40 Union St.
Substation

July 3, 2013

Project Name:	Central Maine Power Substation Improvements	Project ID:	2013-080
Address:	40 Union Street	CBL:	32-I-039
Applicant:	Central Maine Power		
Planner:	Nell Donaldson

SWITCHGEAR ELEVATIONS	
UNION STREET S/S	
PORTLAND	MAINE
CENTRAL MAINE POWER COMPANY SYSTEM ENGINEERING	SS-1
DATE: 2/14/13 SCALE: AS NOTED	REV A

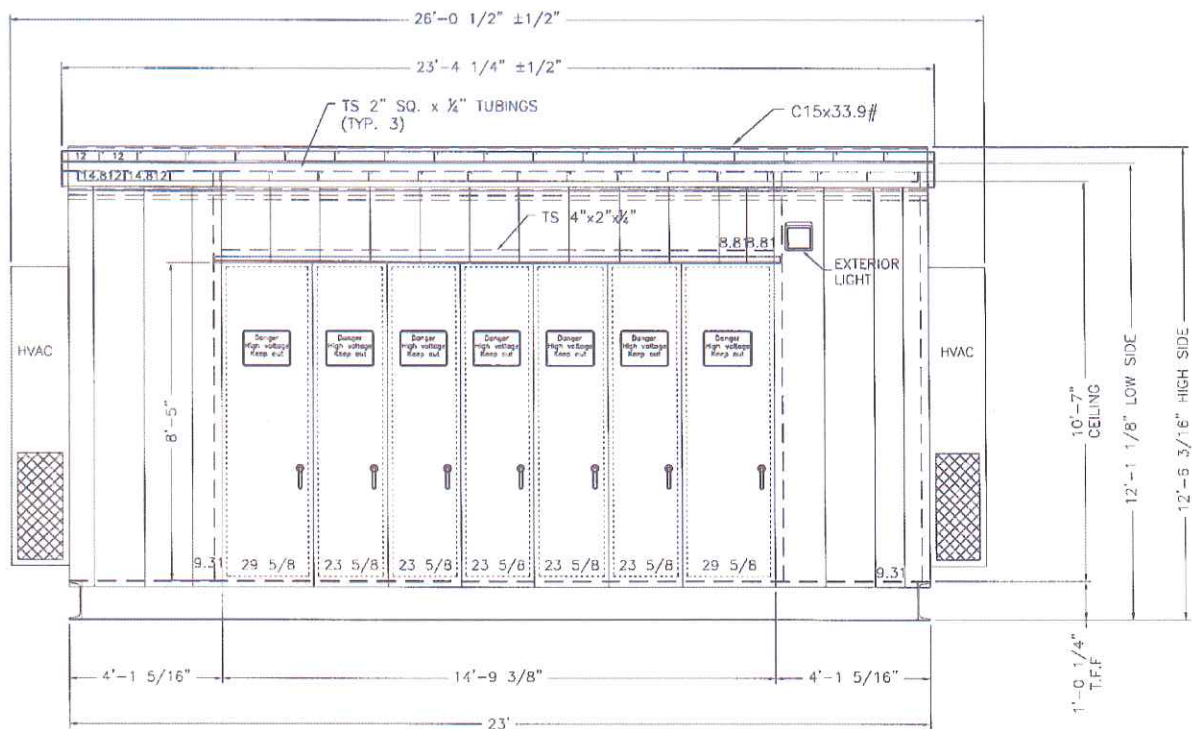
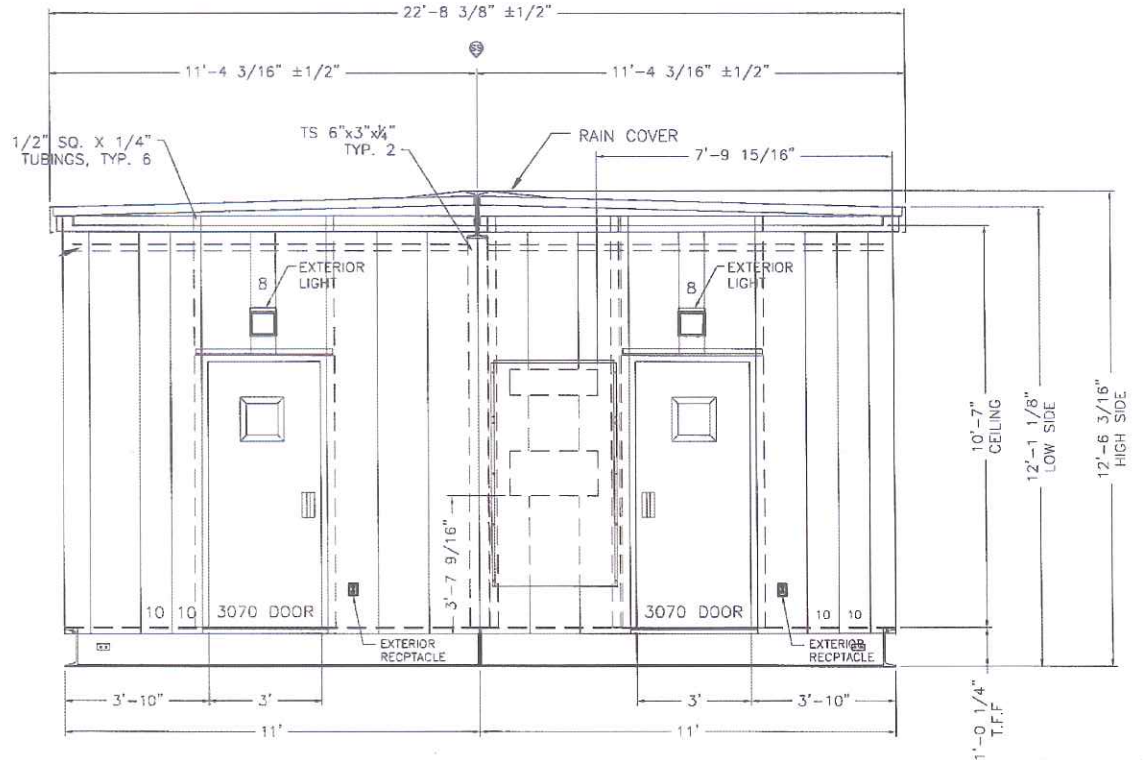
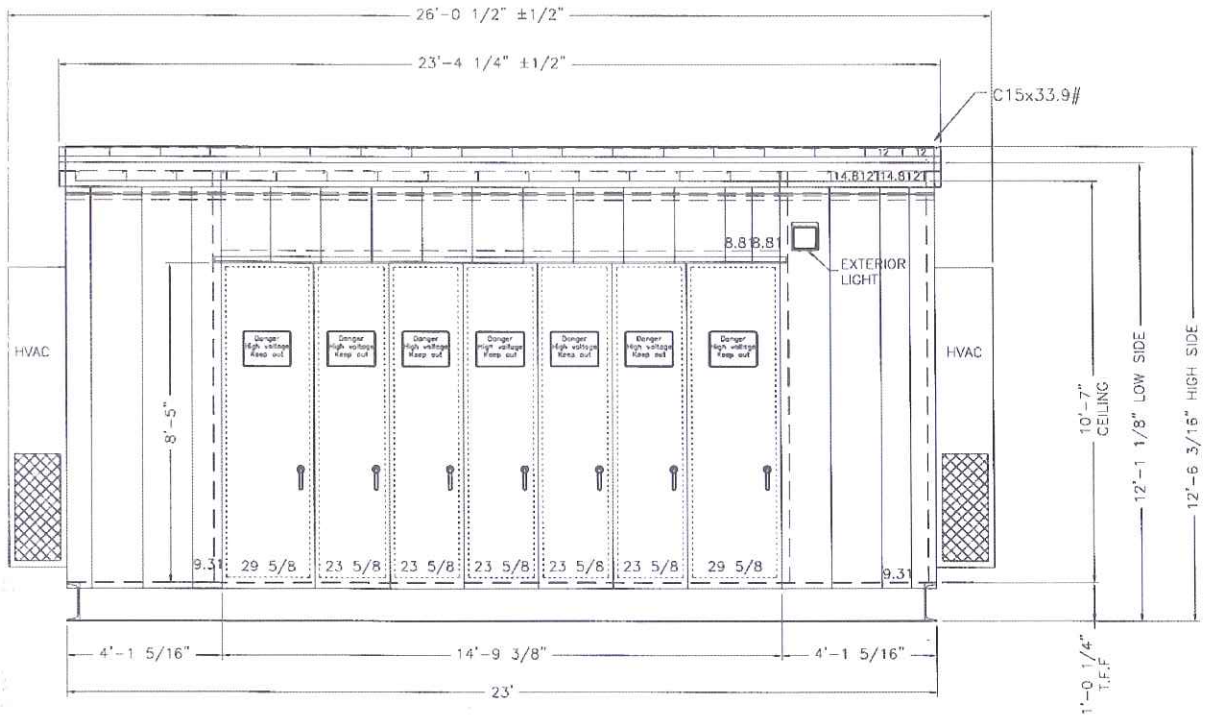
2. The applicant shall:
 - ✓ a. Submit revised elevations showing full cutoff light fixtures on the 11 & 12kV switchgear building, in accordance with the cut sheets provided;

YARD LIGHTING PLAN
SCALE: 1/8" = 1'-0"

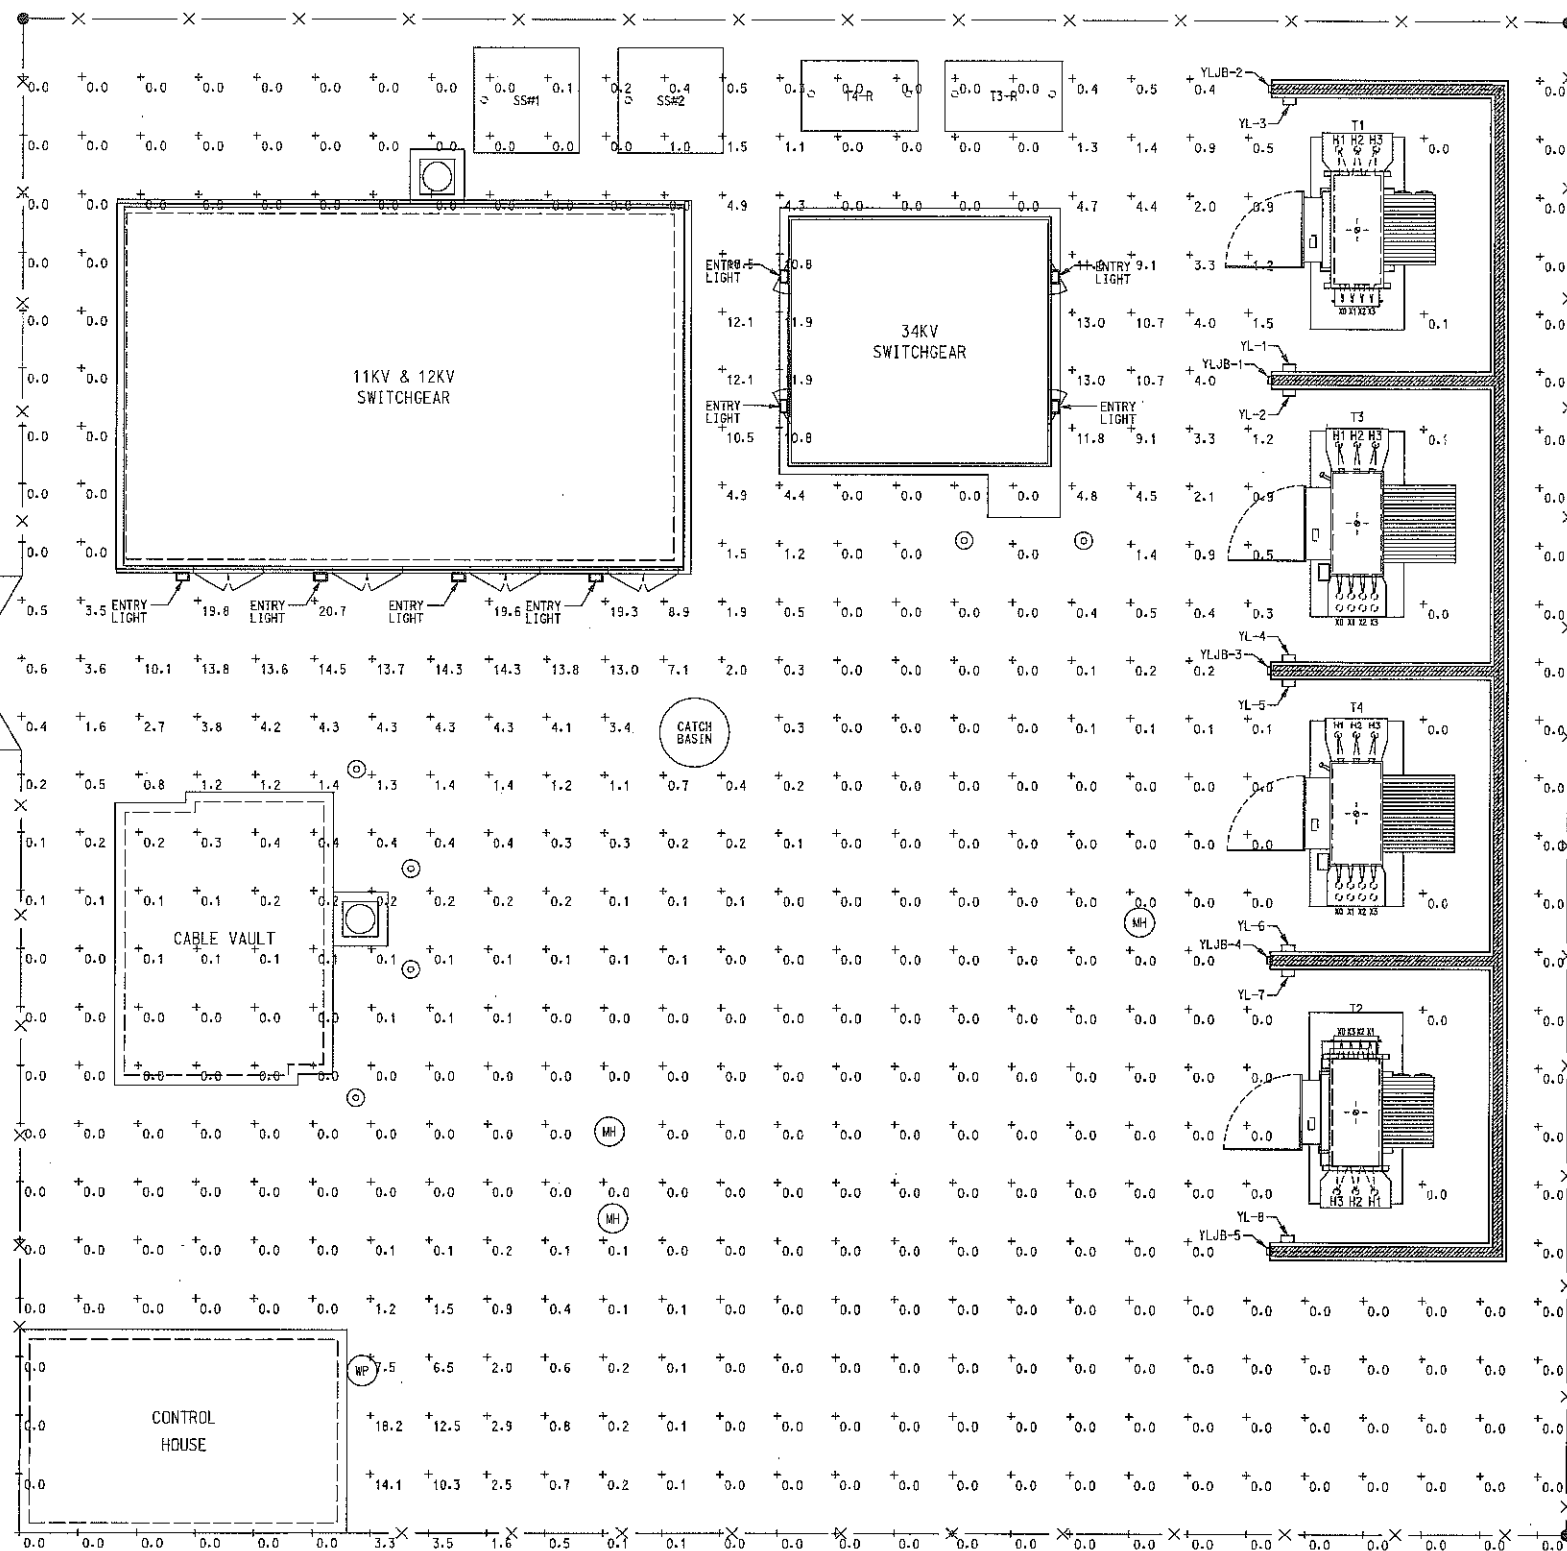
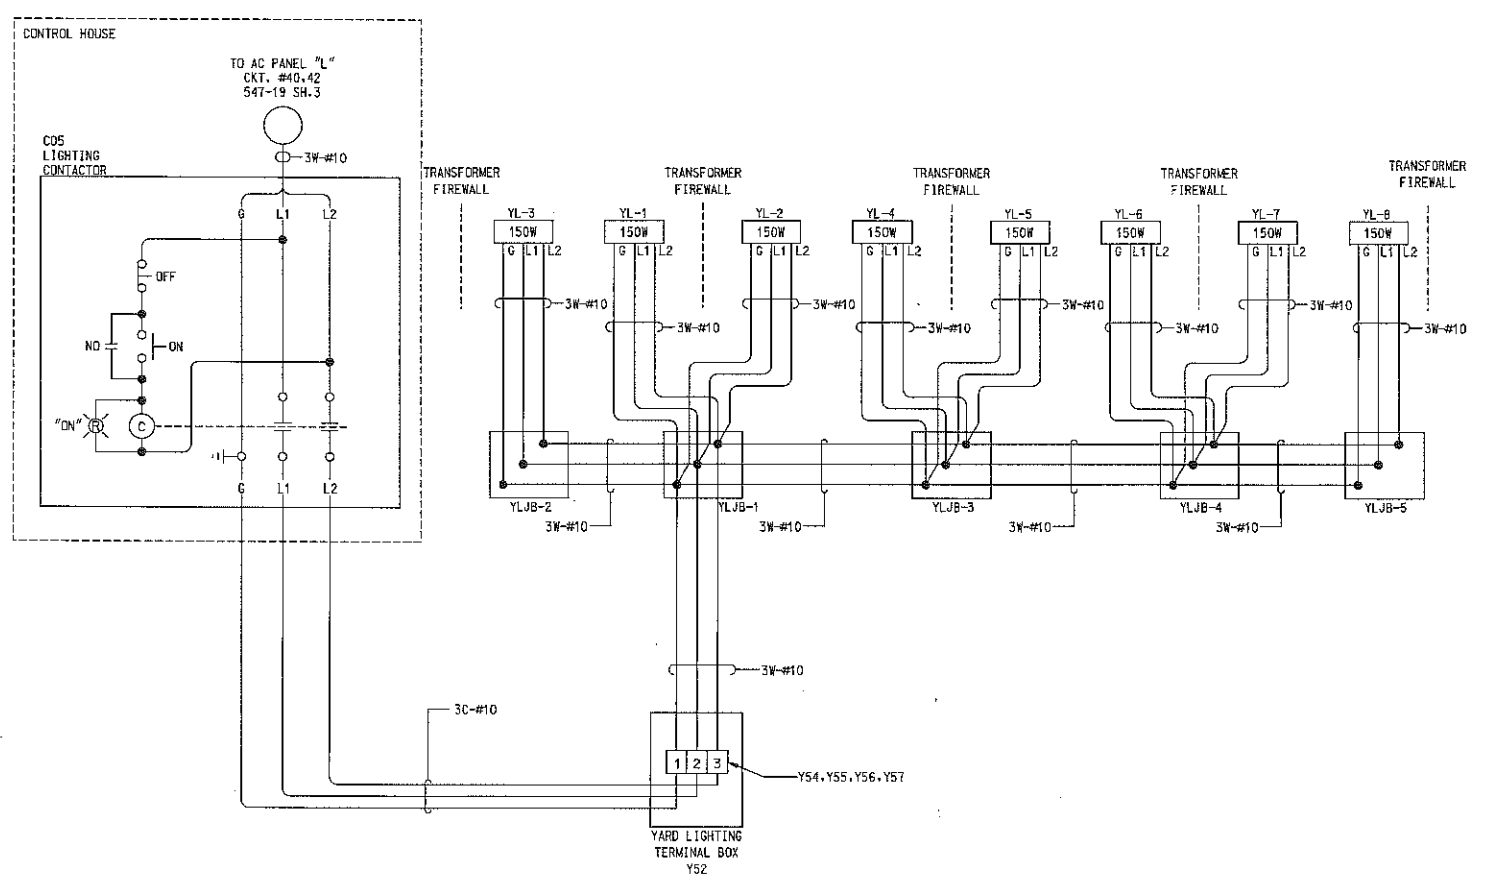
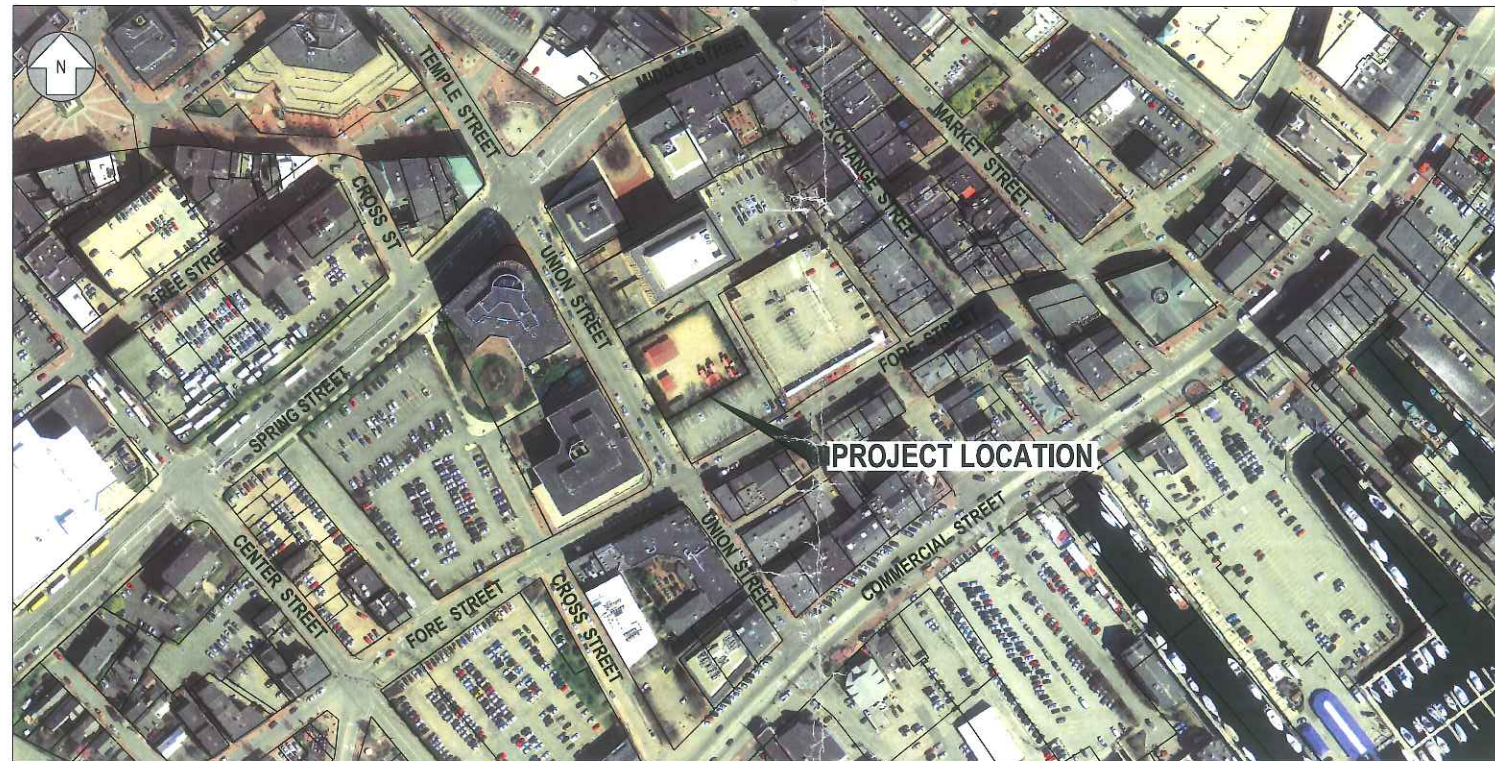
- ok BAB ✓ c. Provide an updated lighting plan, including maximum, minimum, and average illumination levels, based on the revised light fixtures and add a note to the lighting plan which indicates that the transformer lights will be switched on only temporarily for maintenance or emergency purposes.
